ENG-PUDSP20001-R1-PUDSP-Redlines Summary_Markup Summary

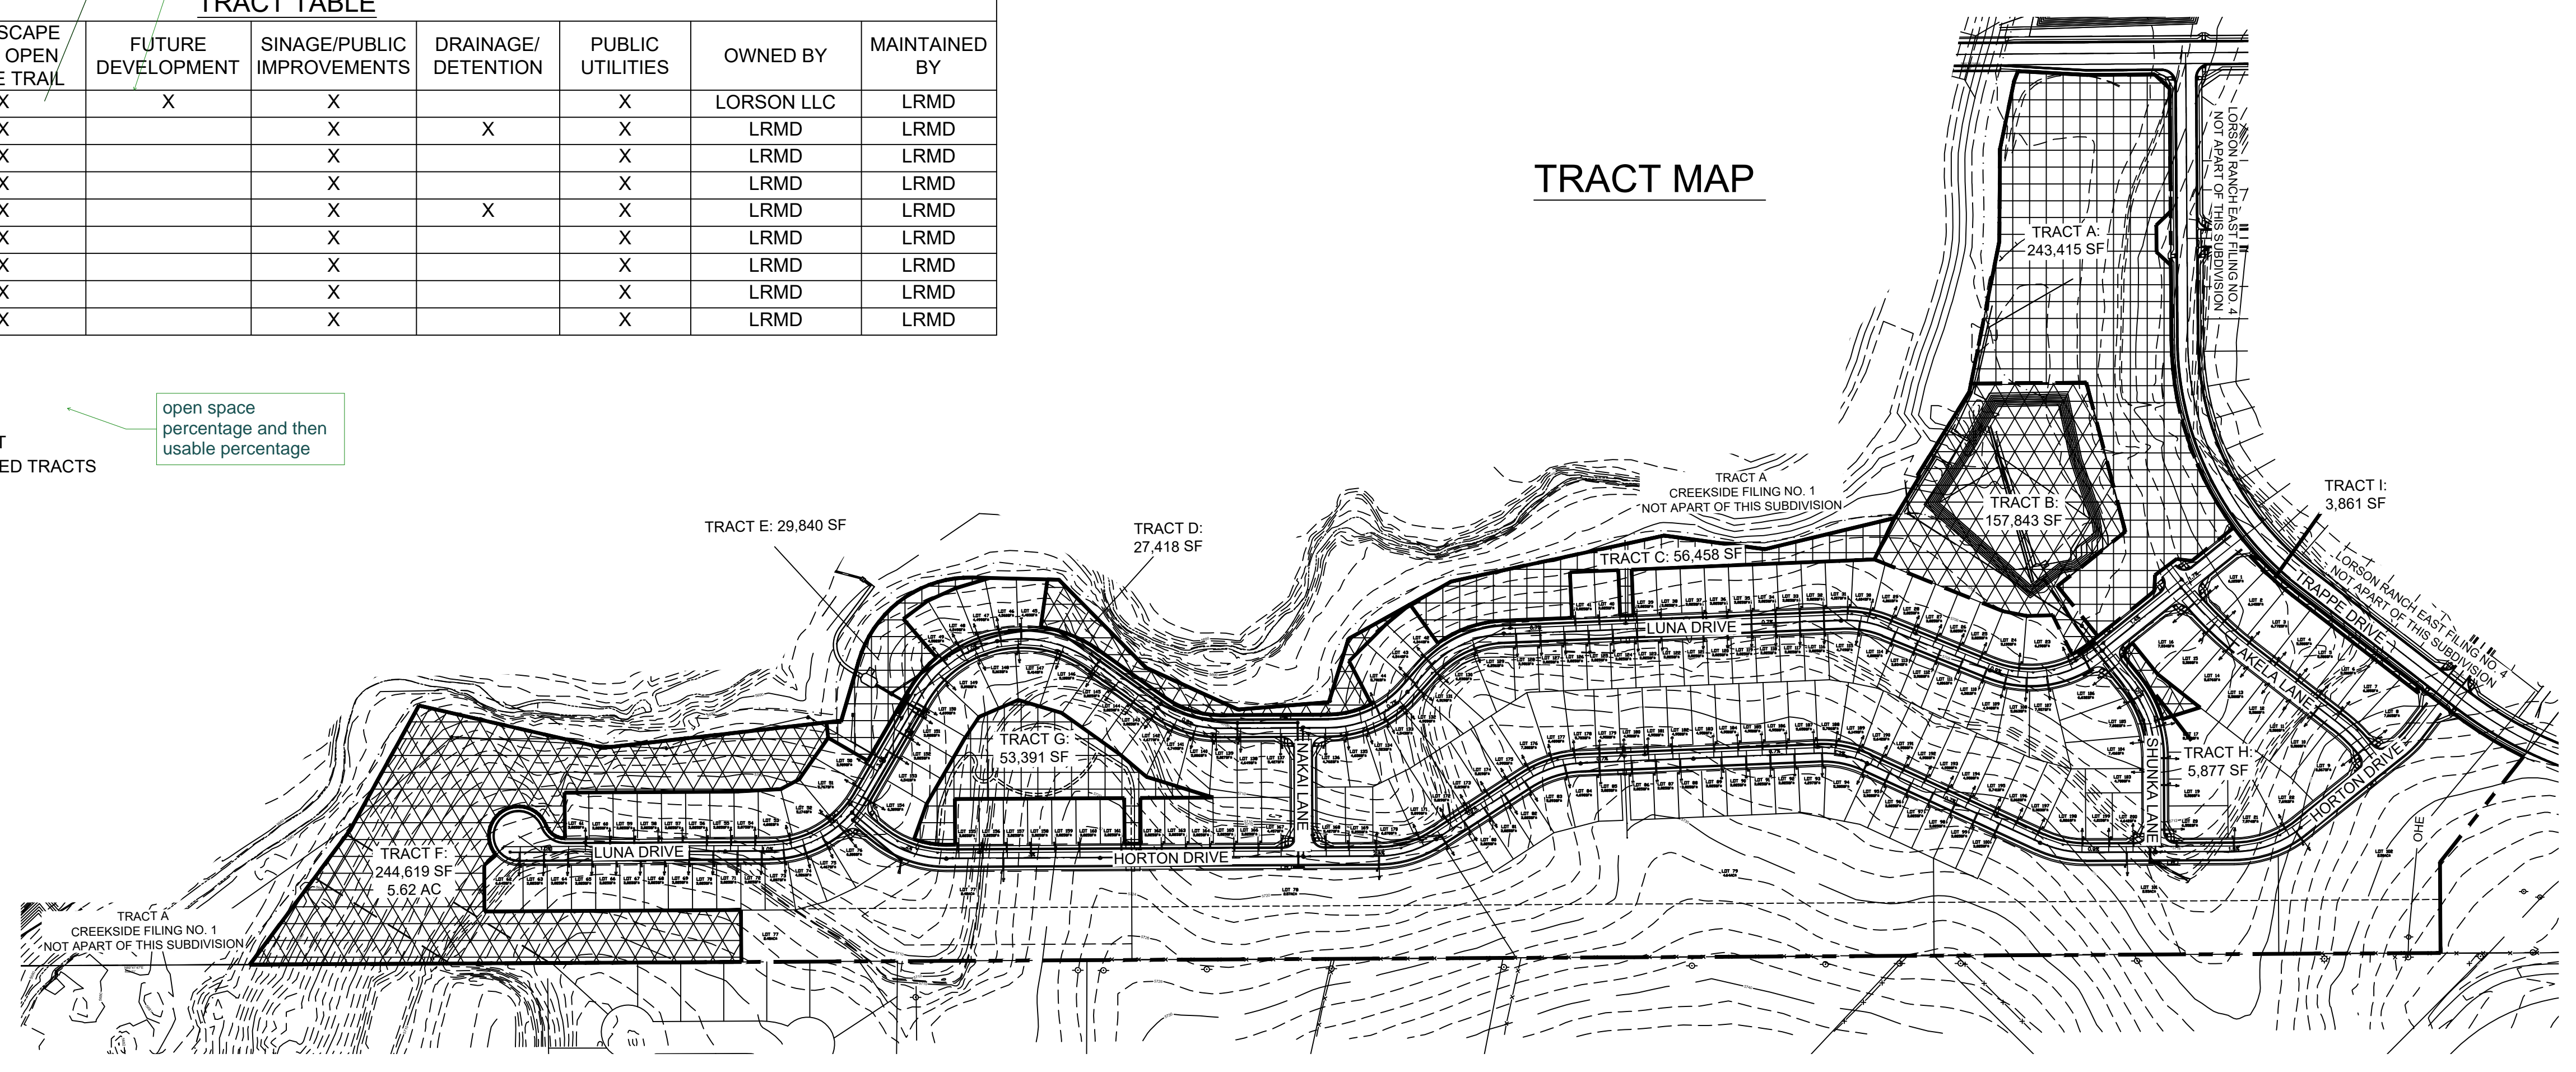
is there a new LOMR?

a tract is not both of these uses-either is a future dev tract and not open space or its open space. IF future development and what will that be and when? theres no mention of this in LOI...

open space percentage and then usable percentage

SHEET MAP

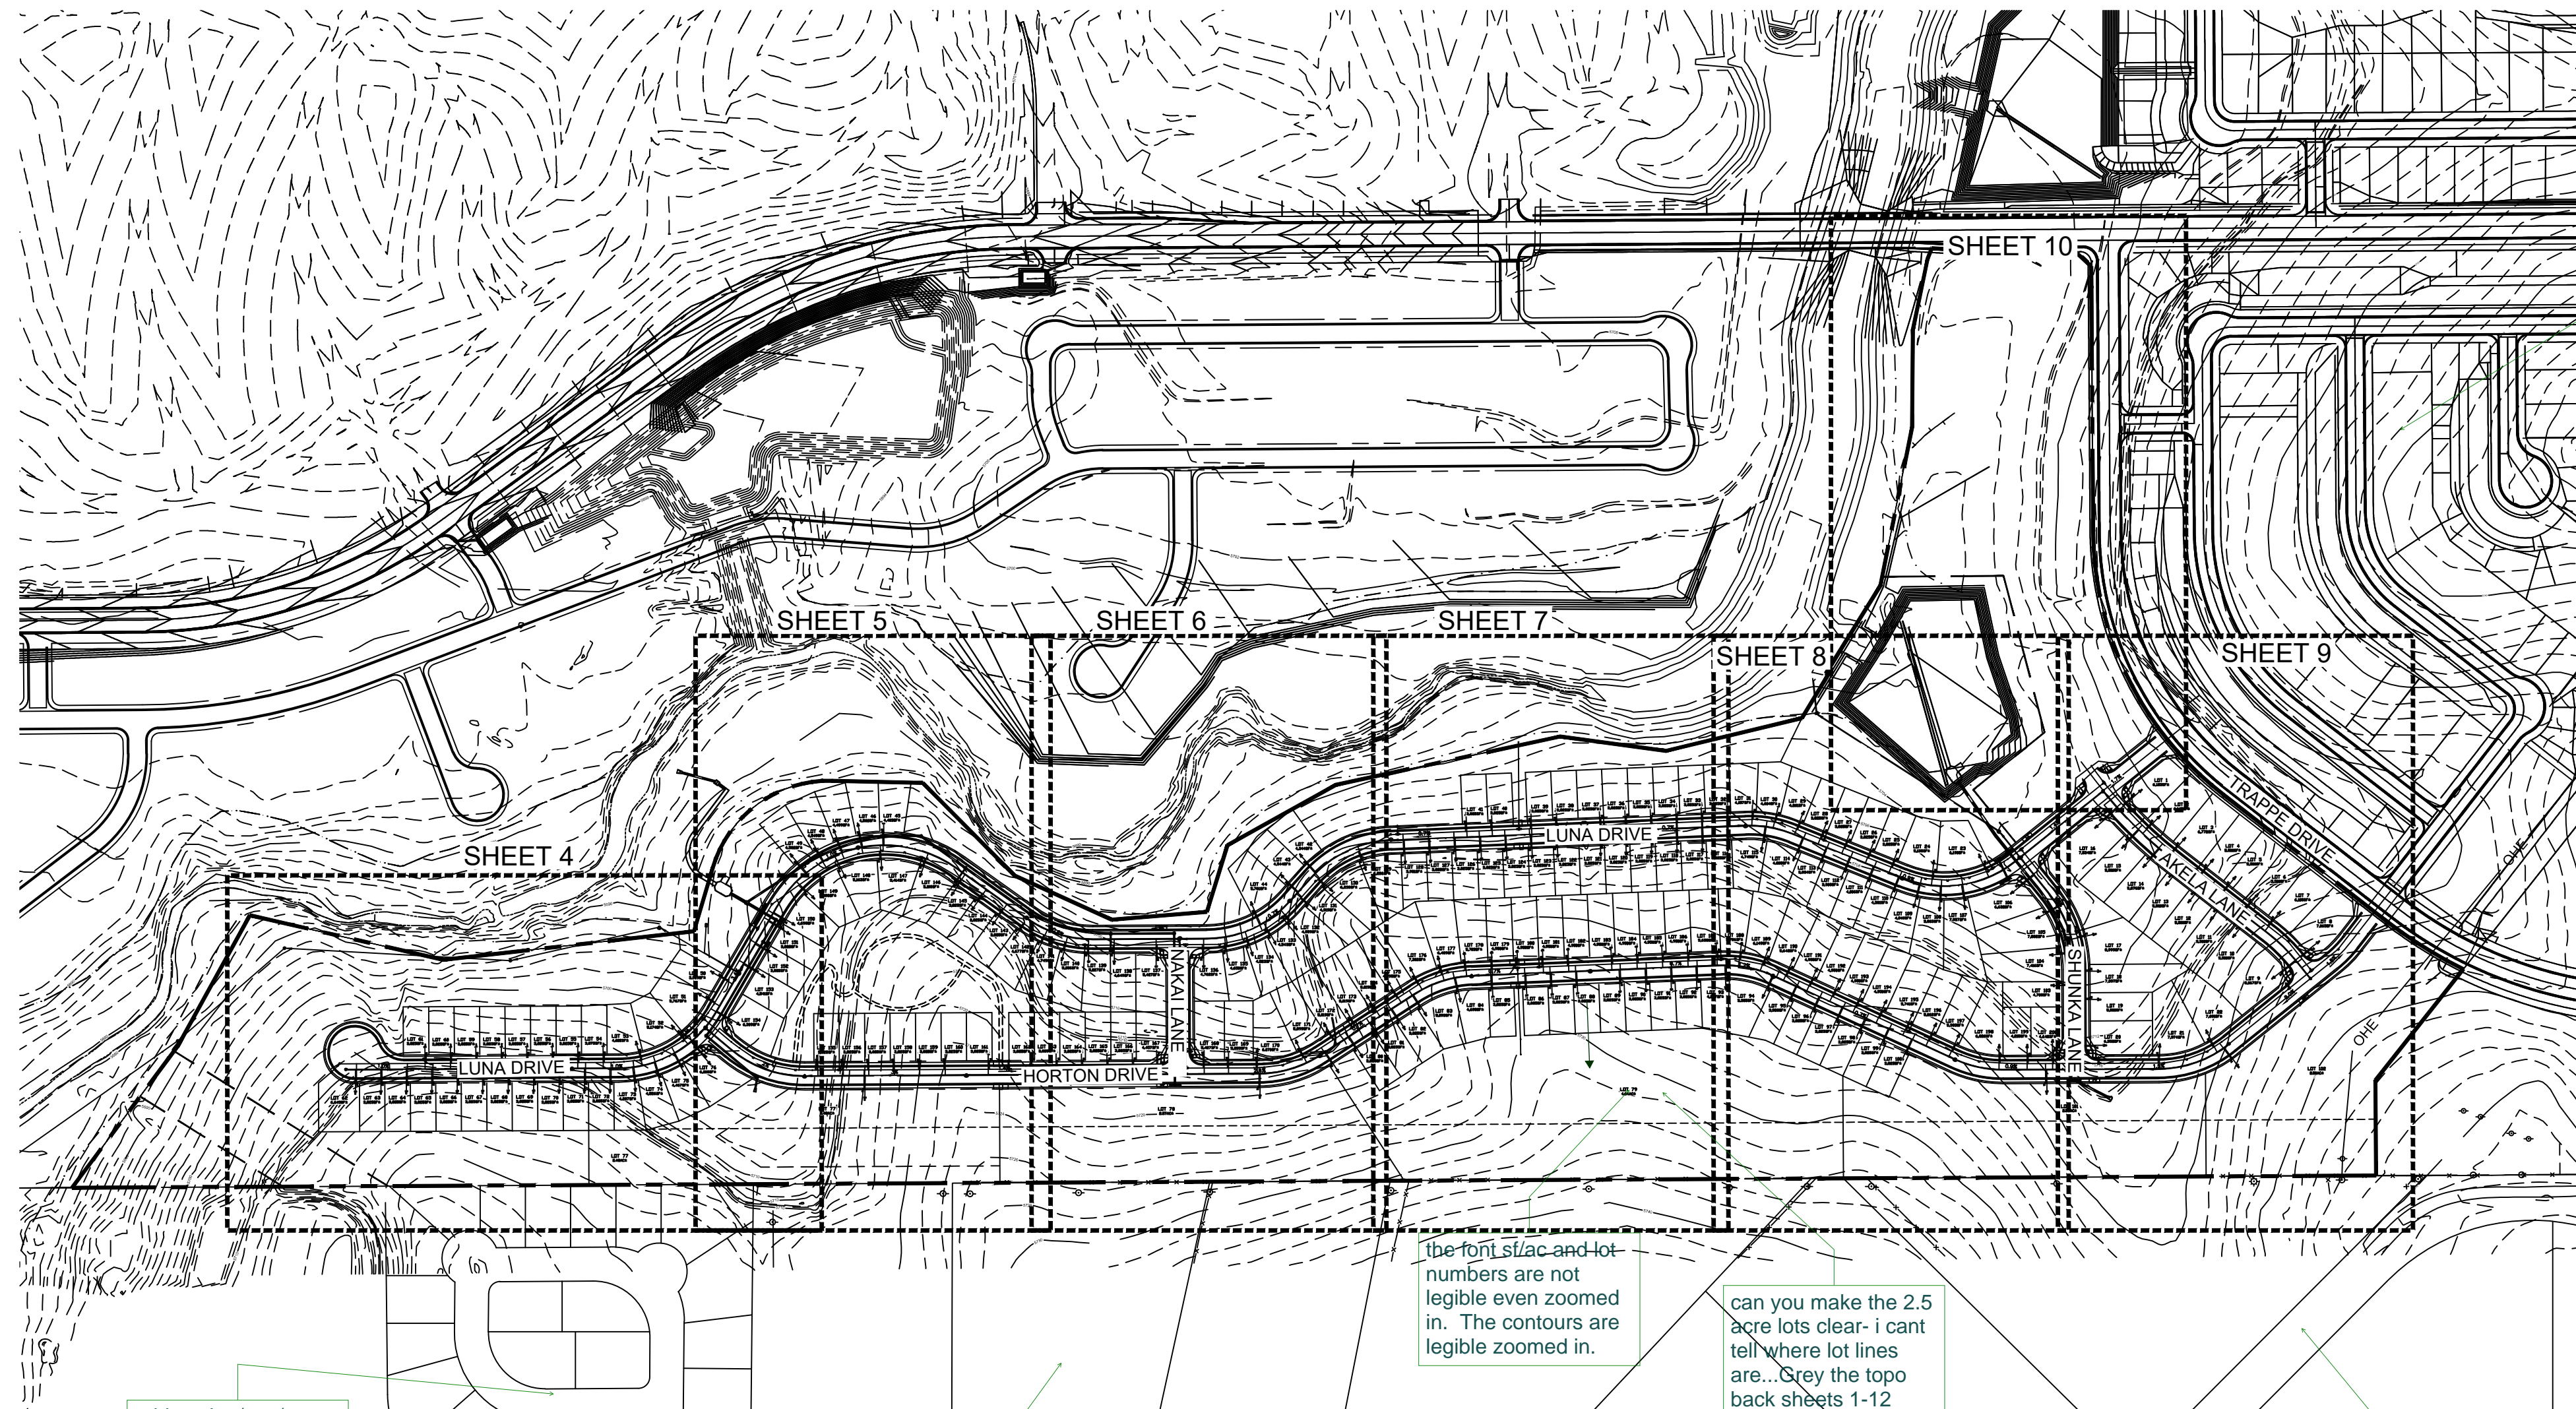
gray back approved developments not apart of this all sheets

can you make the 2.5 acre lots clear- i cant tell where lot lines are...Grey the topo back sheets 1-12

PUD DETAILS & DATA

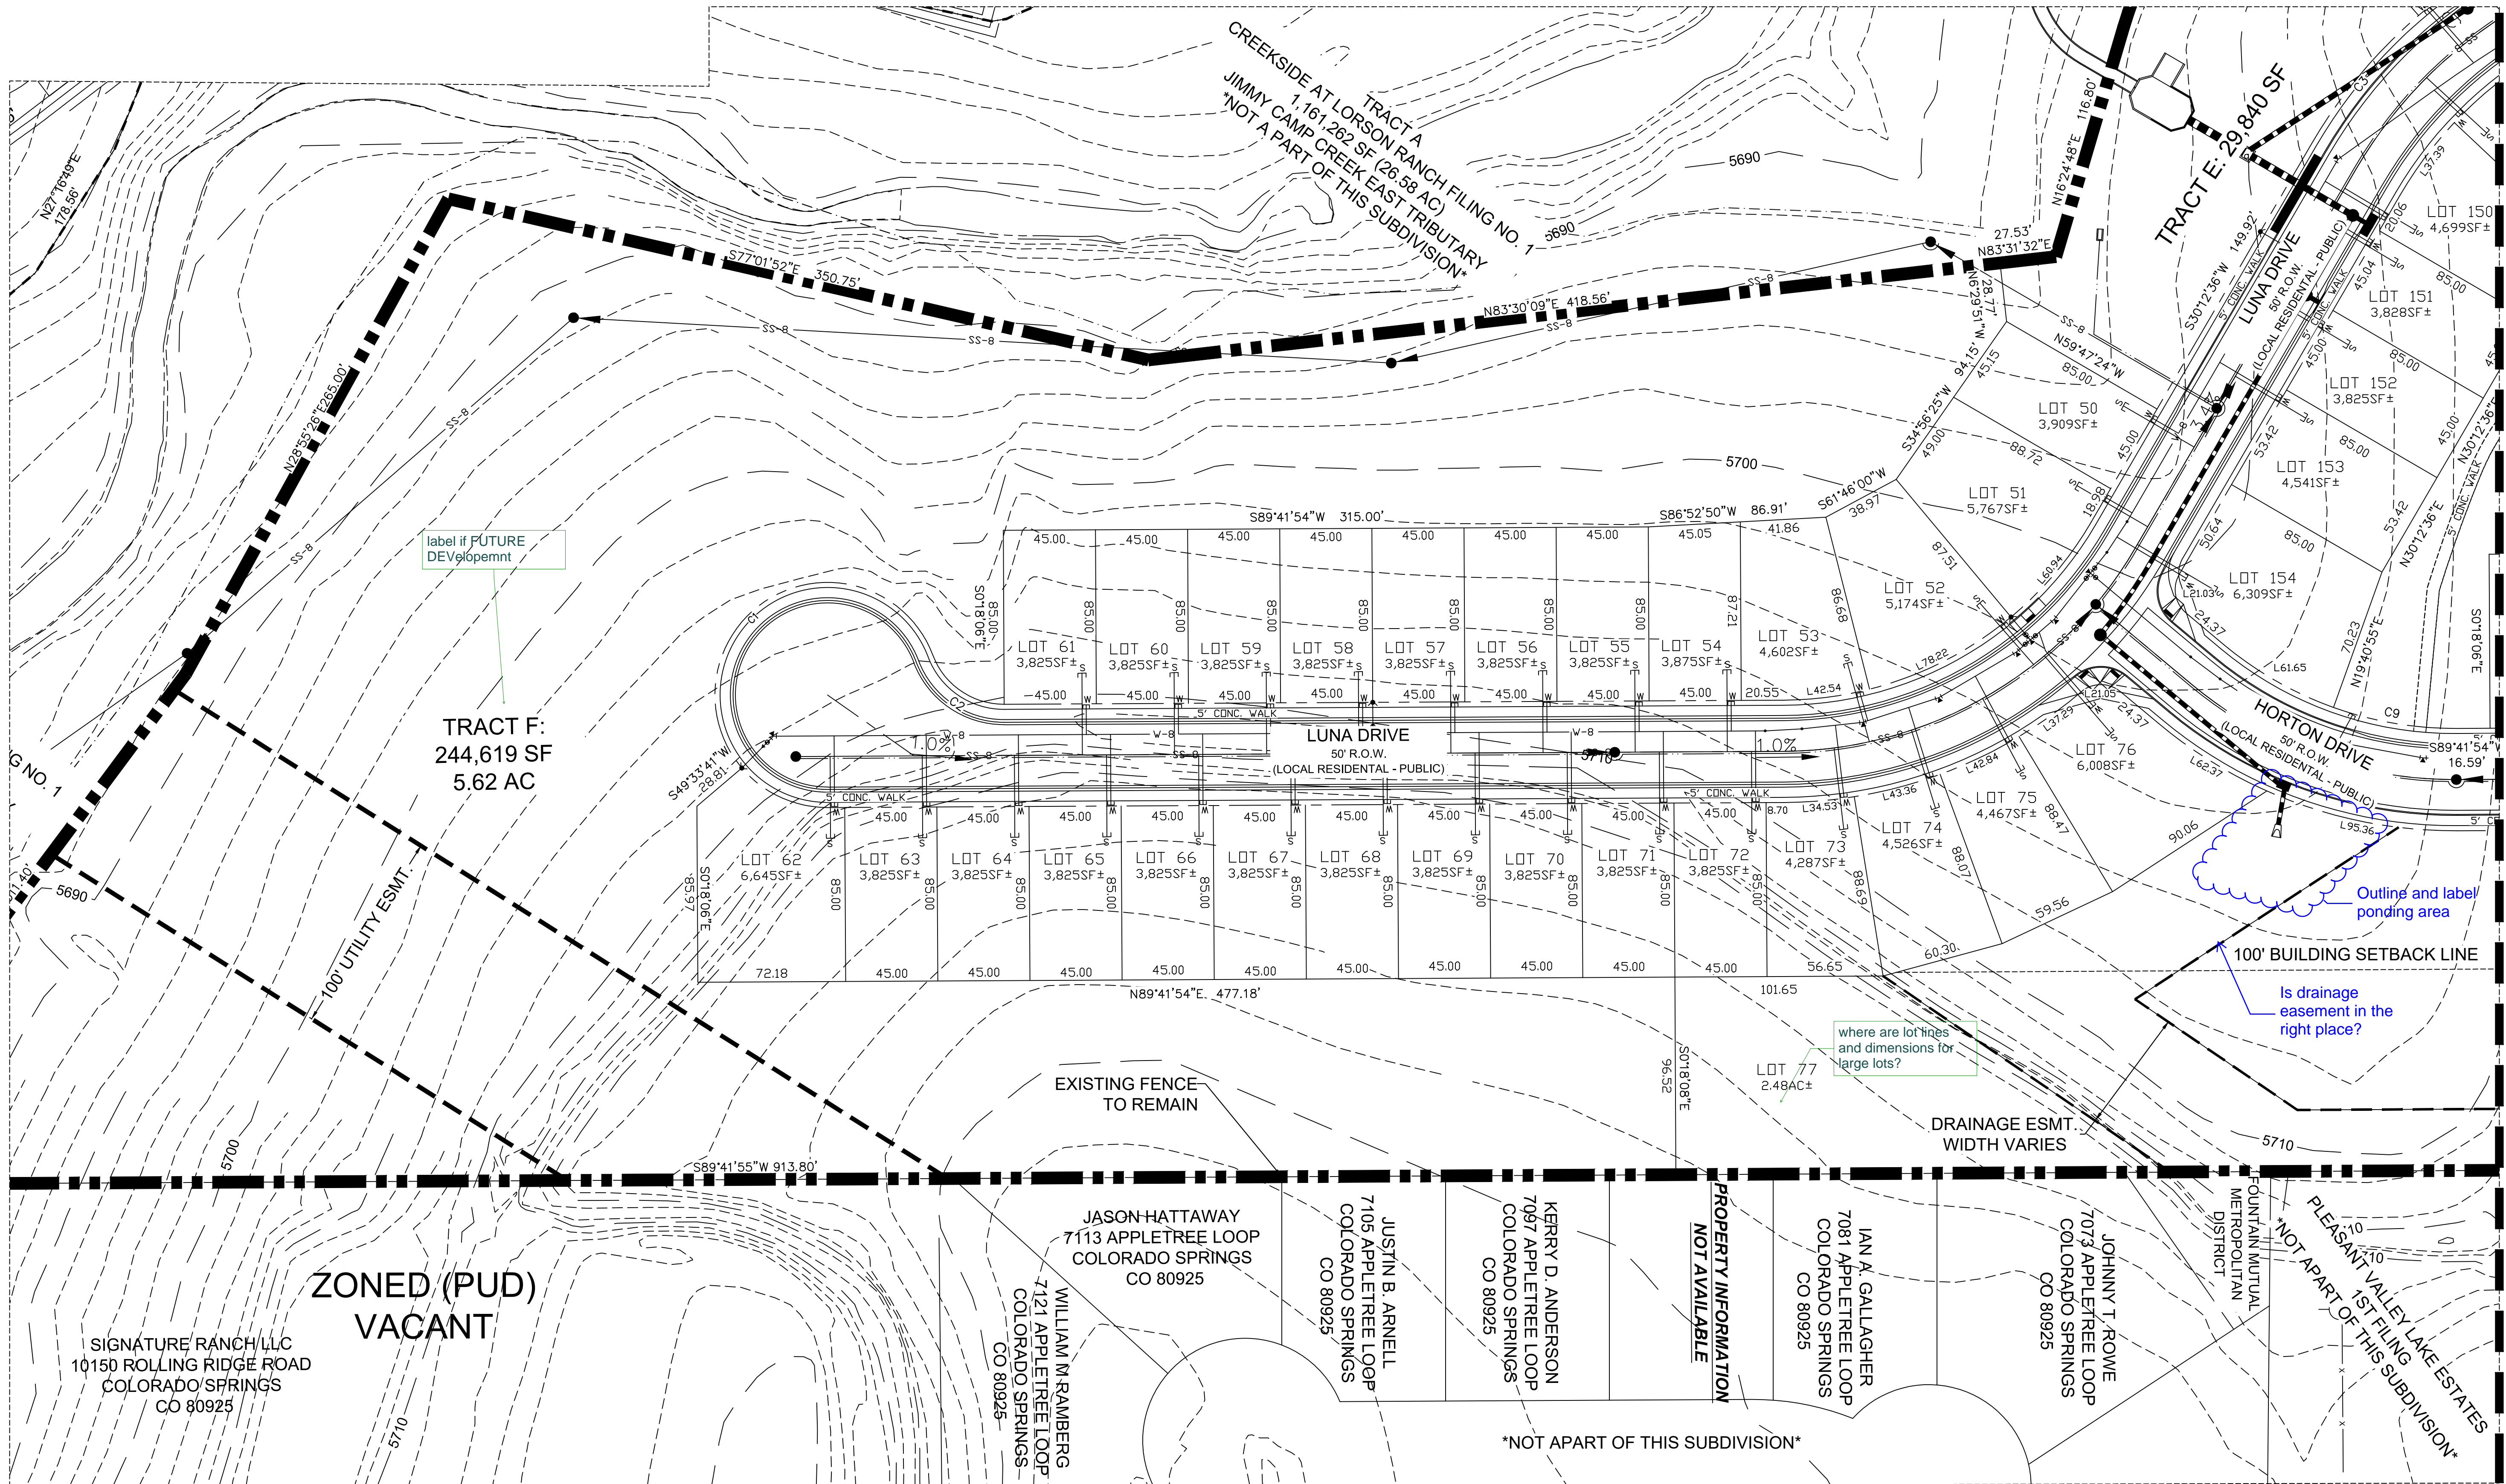
Recommend deleting this text except for note #1

the font sf/ac and lot numbers are not legible even zoomed in. The contours are legible zoomed in.

what is this road? - does that need to go away

accessory structure setbacks please (barns for horses? Detached garages on rural lots)
